Date: November 10, 2003
Architect's Project No.: 03034

**ADDENDUM NO. 4
TO
CONTRACT DRAWINGS AND SPECIFICATIONS
FOR
GULF OF MAINE RESEARCH LABORATORY
Portland, Maine**

FIRST FLOOR PLAN

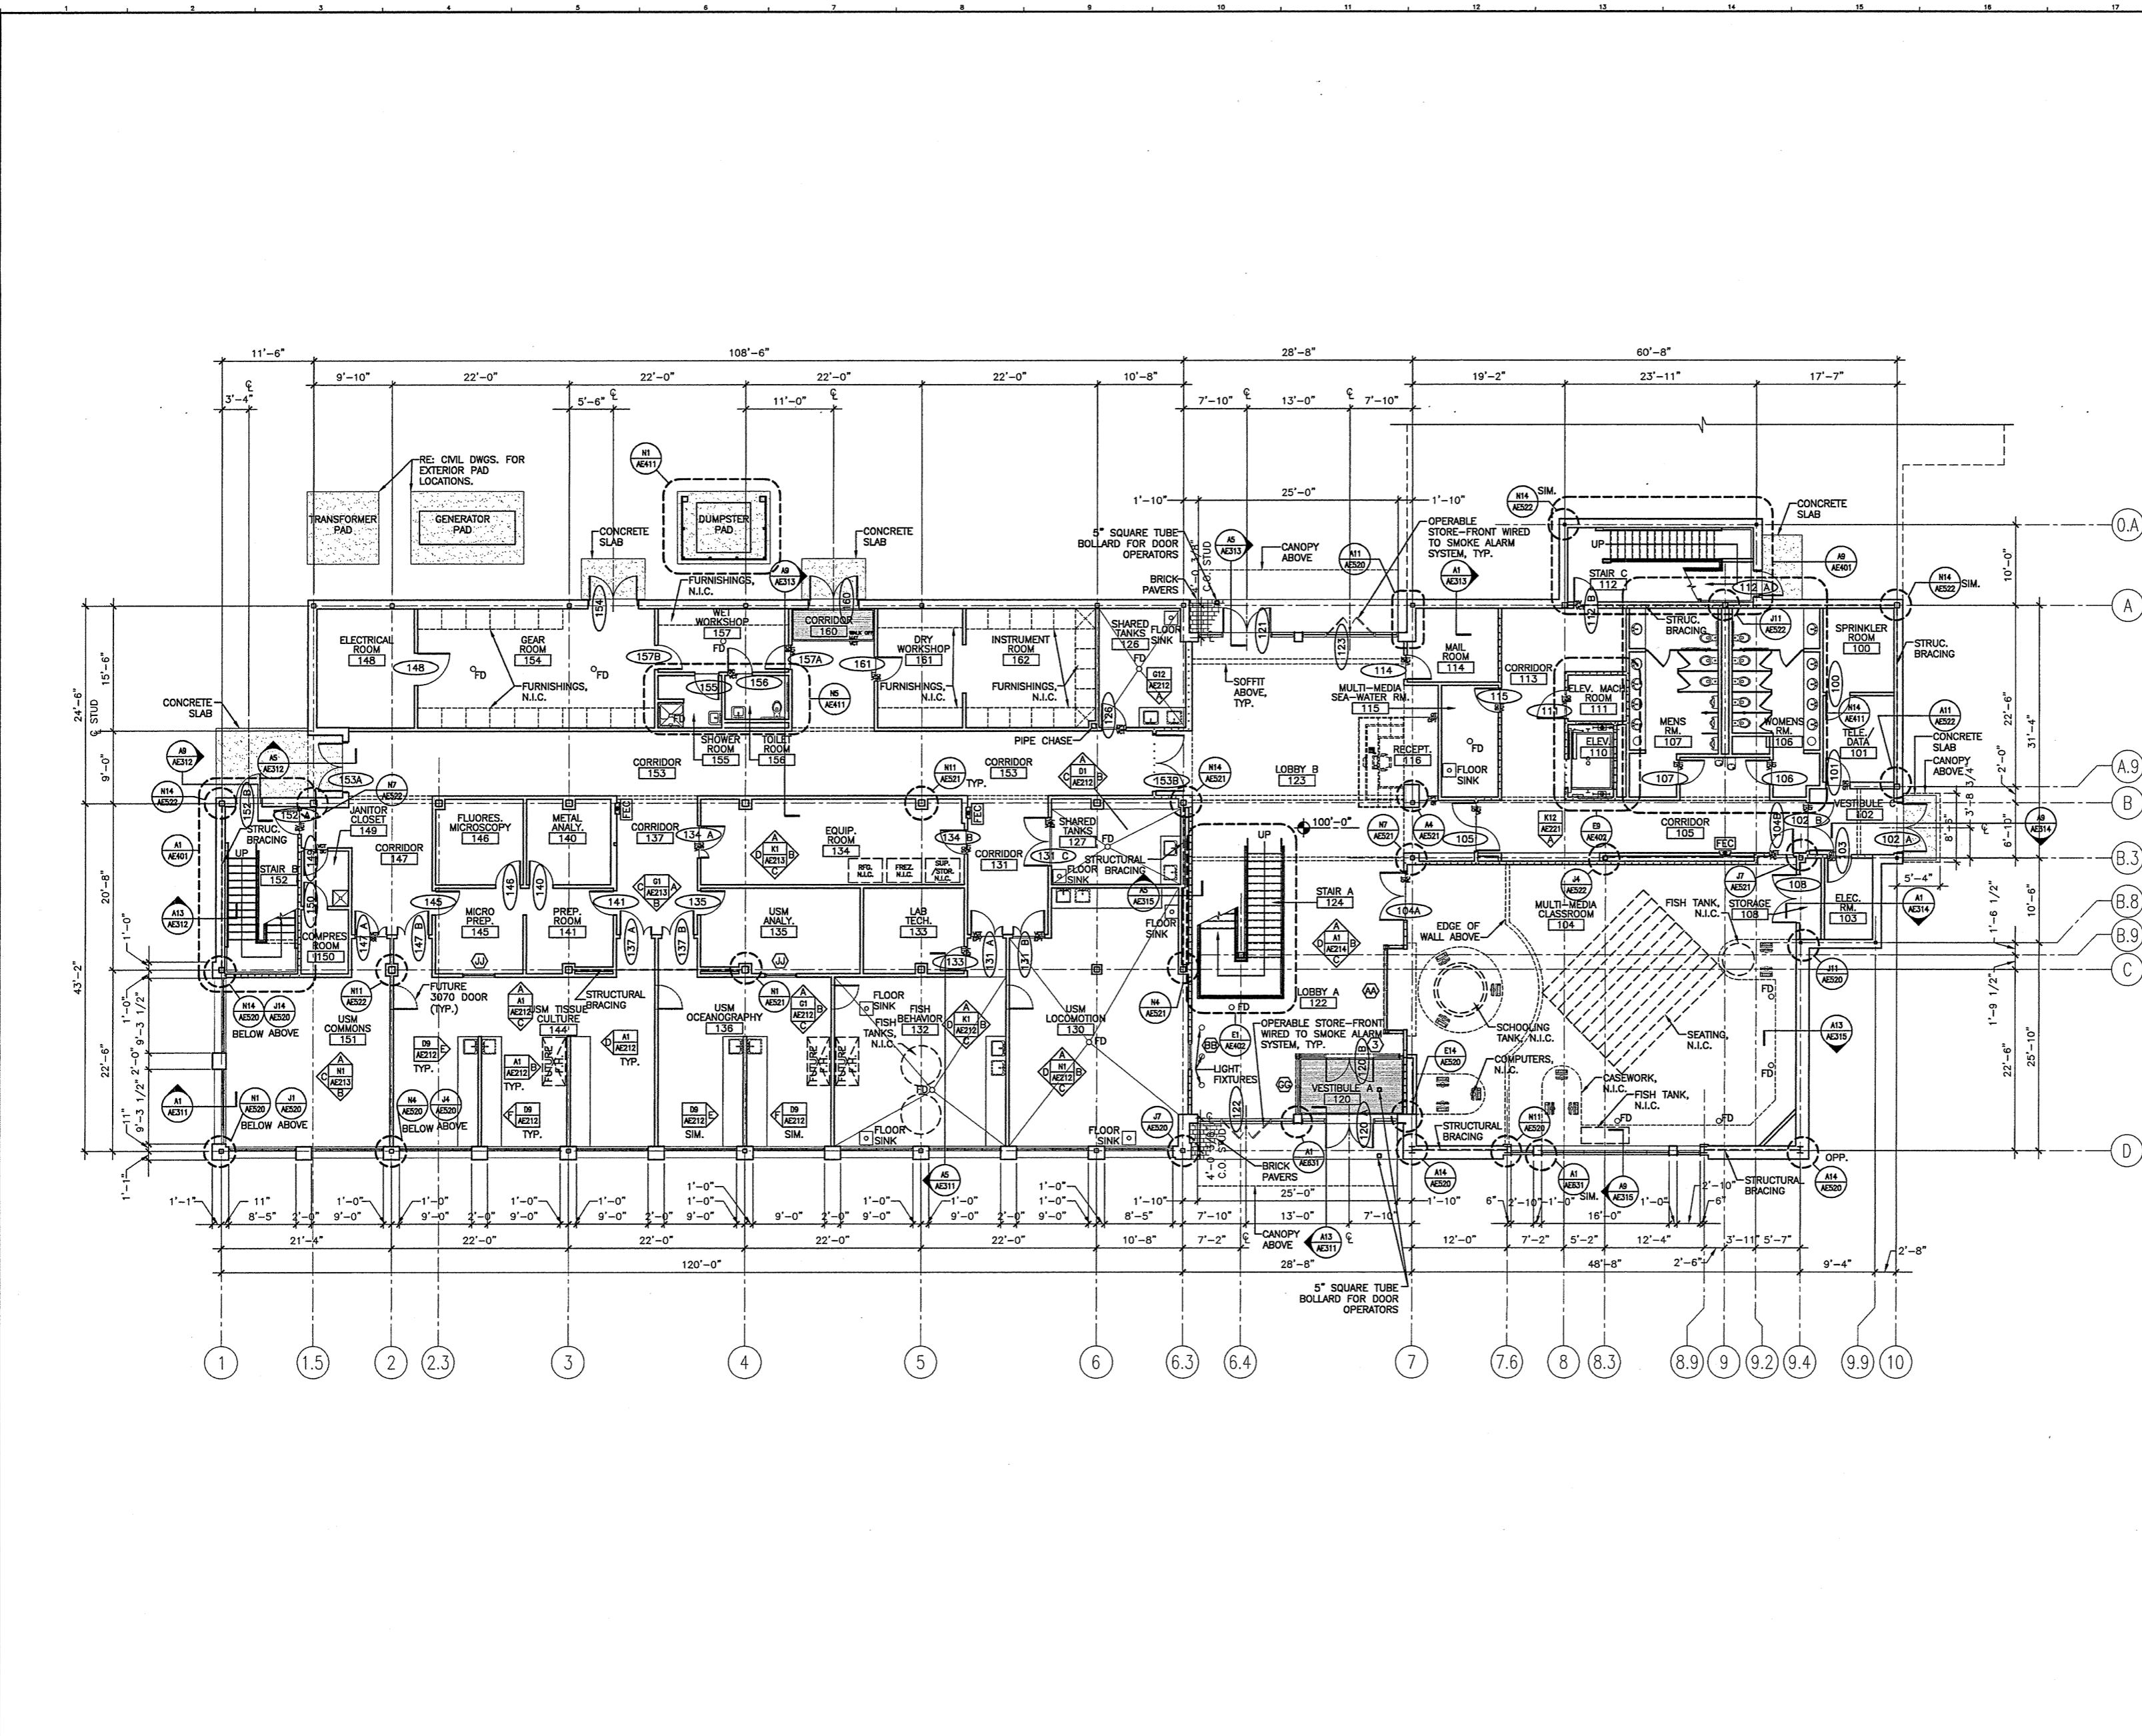
- B. General Notes. Add: "2. Provide two layers of 5/8" gypsum board on interior side of Stair C exterior walls for future fire rating."
5. Drawing Sheet AE101, AE105, MH101, etc. Reverse the swing of door 104B to be right hand reverse.

6. Drawing Sheets AE101 and AE105, Corridor 105. Add second wall recess and second set of lunch box shelving and hooks to corridor west wall. Add second elevation reference "K12/AE221".

FIRST FLOOR SEAWATER SYSTEM PIPING PLAN

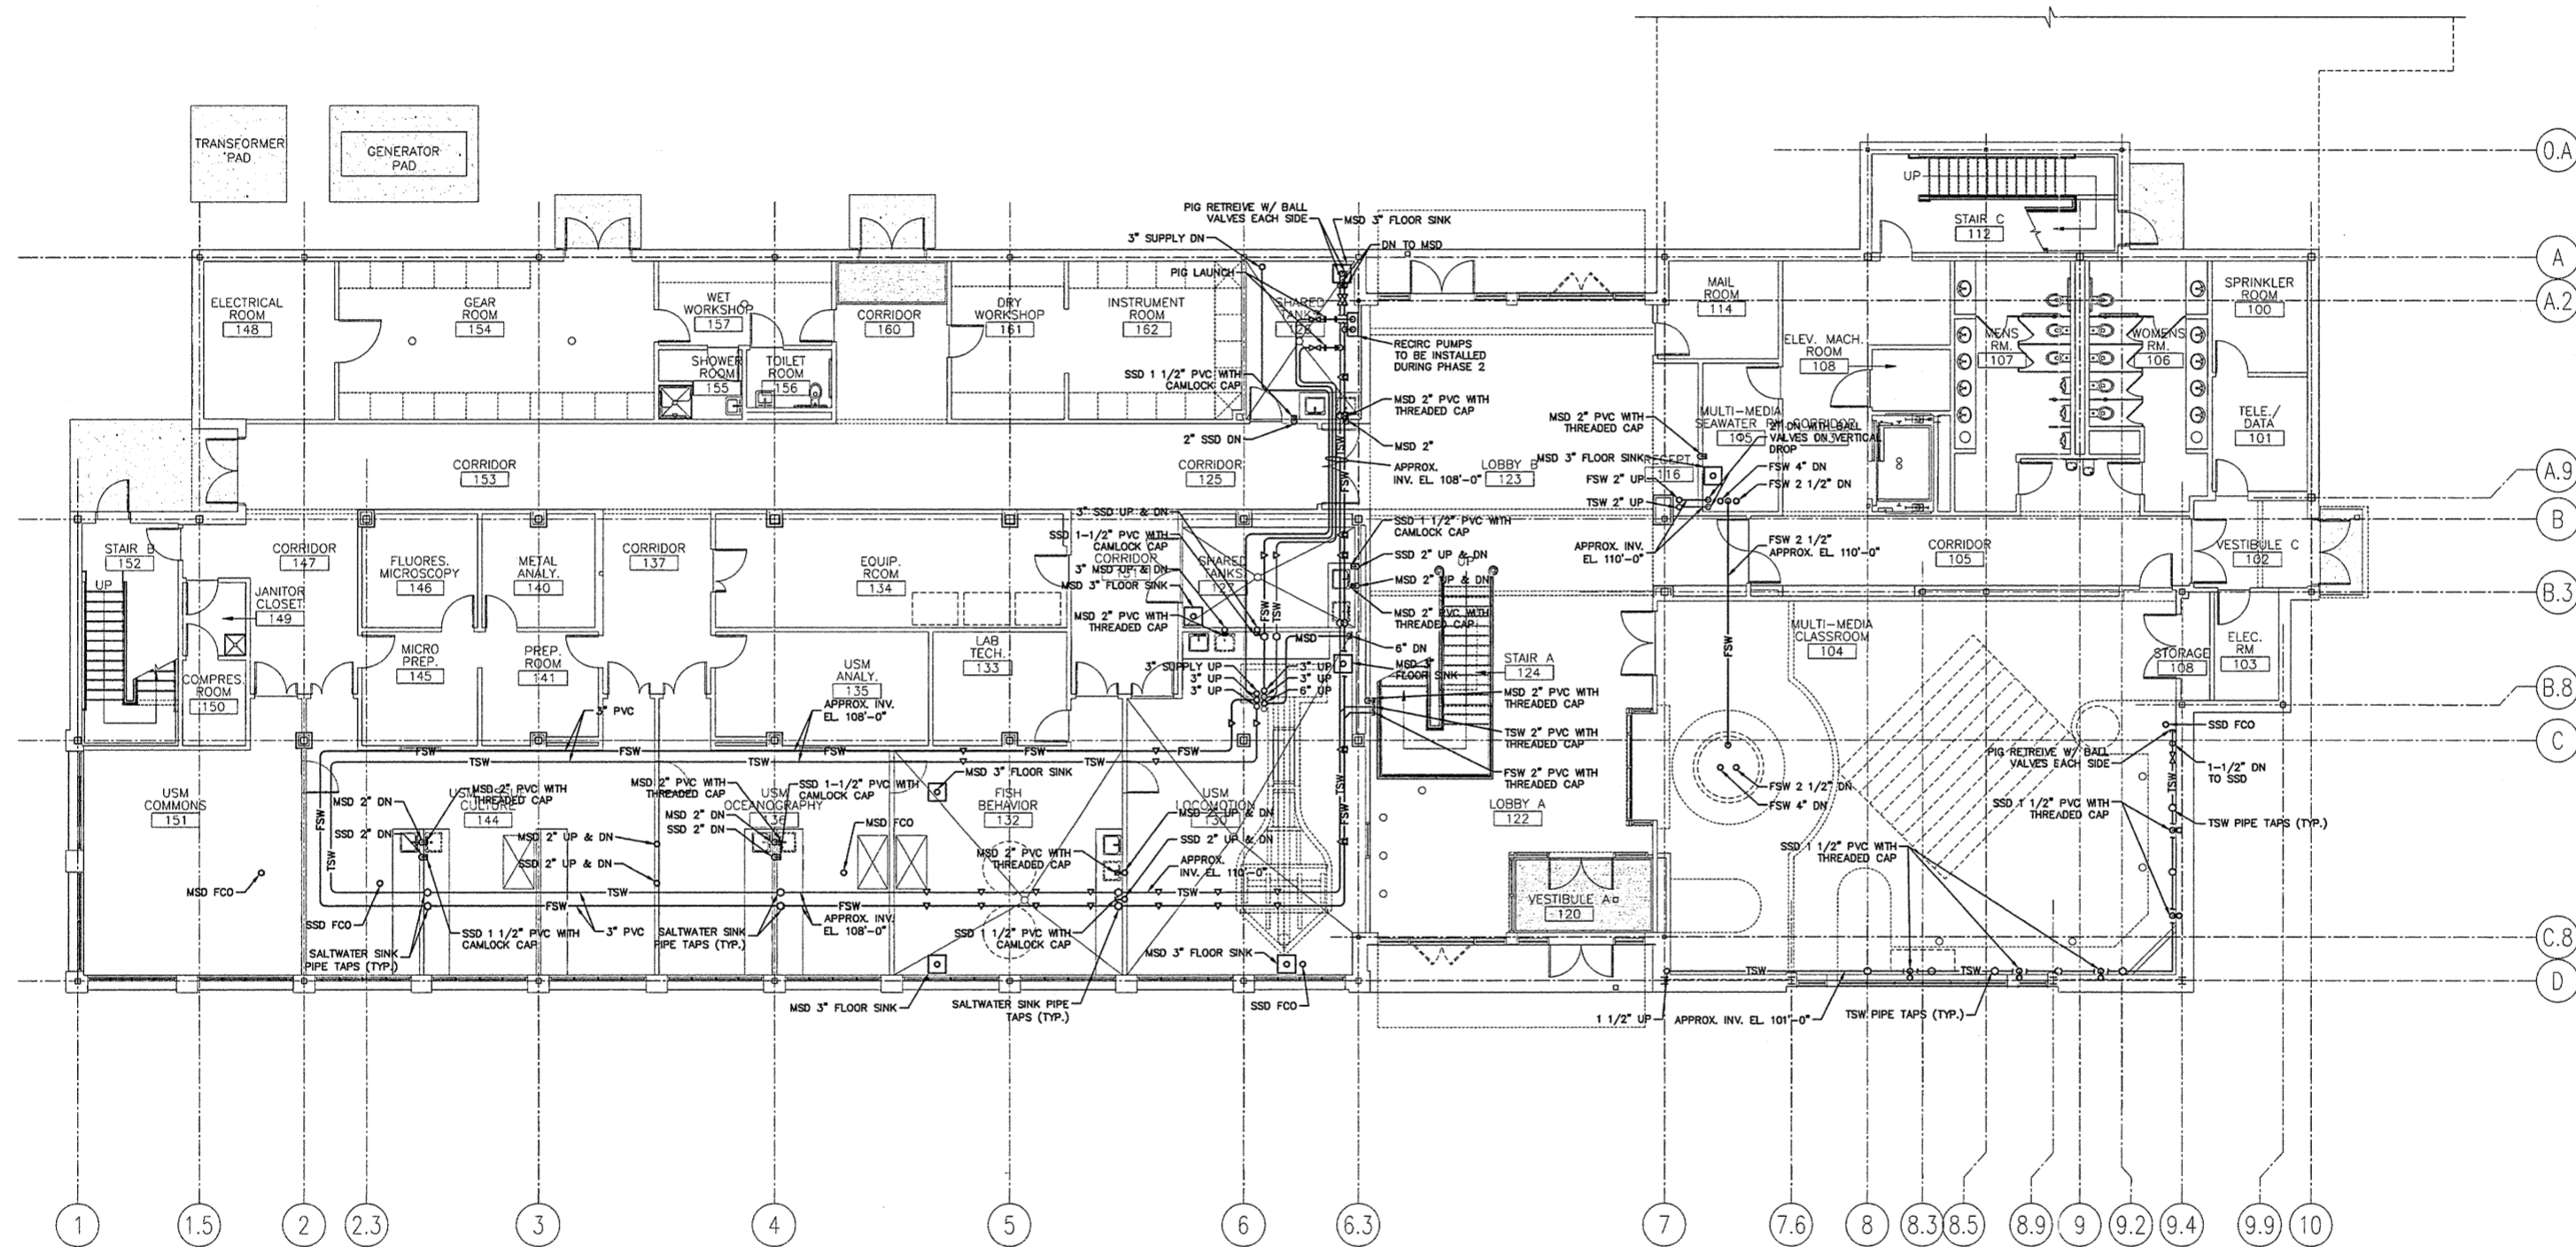
22. Drawing Sheet SW104:
 - A. Change elevation of FSW and TSW piping from "APPROX. INV. EL. 108'-0"" to read: "APPROX. INV. EL. 108'-6"".
 23. Drawing Sheet SW108. Delete detail "H – Seawater Riser Detail" and replace with detail "H – Seawater Riser Detail" as shown on attached sketch ADD4-SW1.

THIRD FLOOR
LIGHTING PLAN

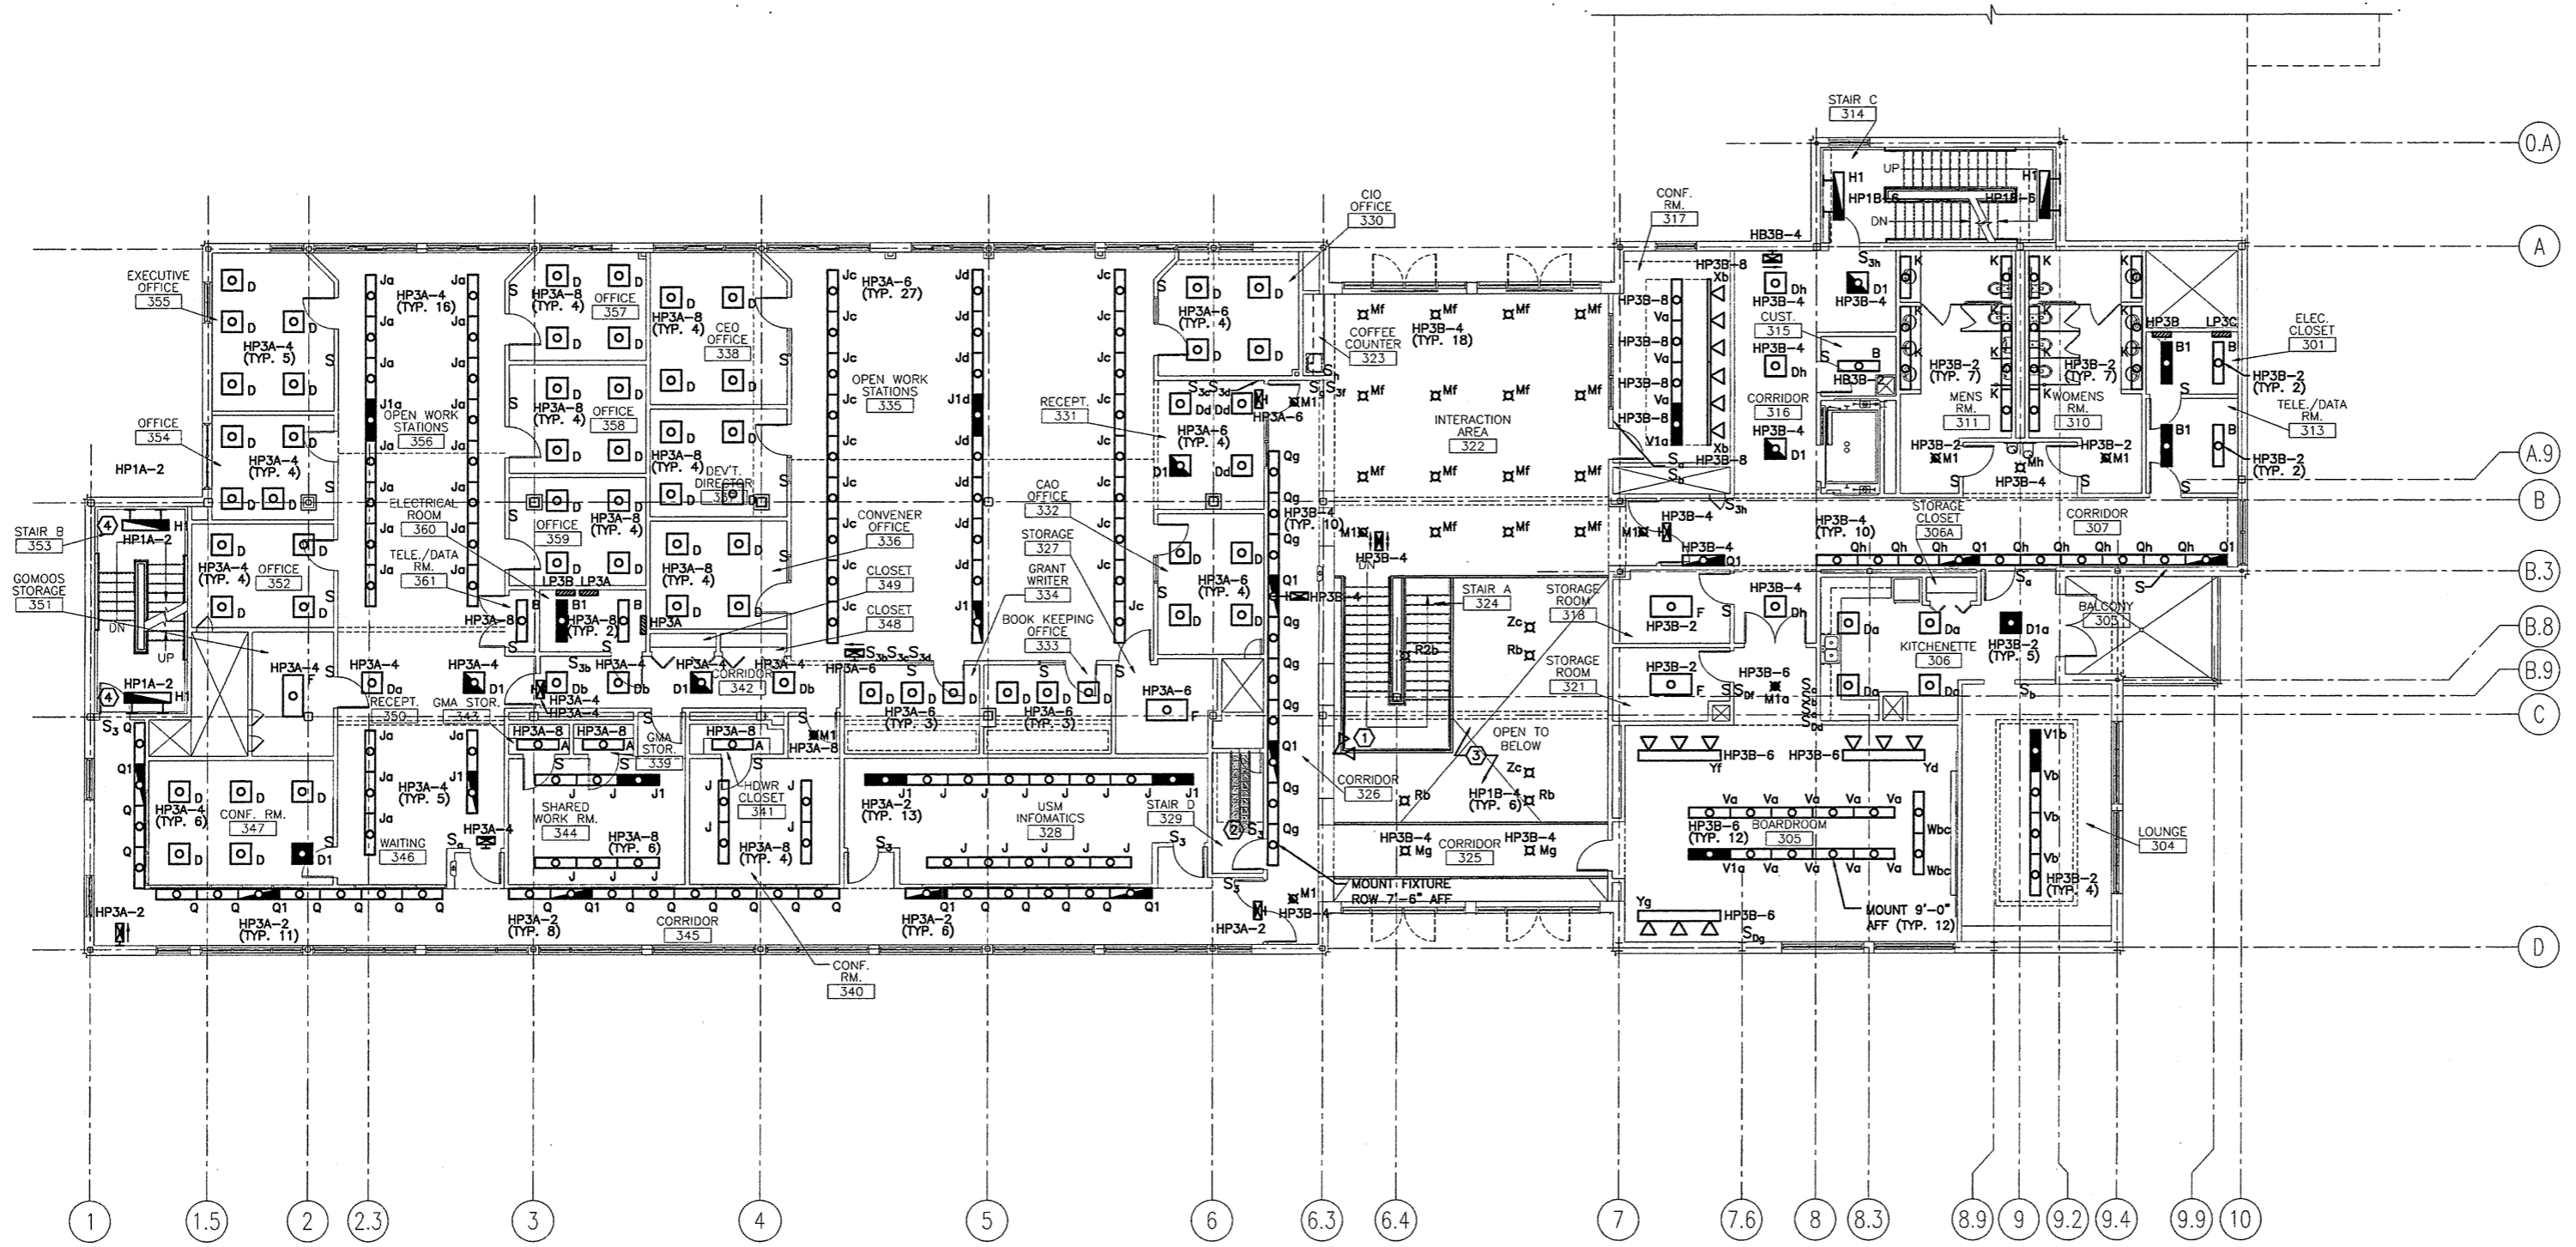
25. Drawing Sheet EL101. Multi-Media Seawater Room 115. Revise light switch location to be adjacent to revised door location.
 26. Drawing Sheet EL103. Boardroom 305. Locate light switches SDg and SDf to vestibule south wall near other light switches.
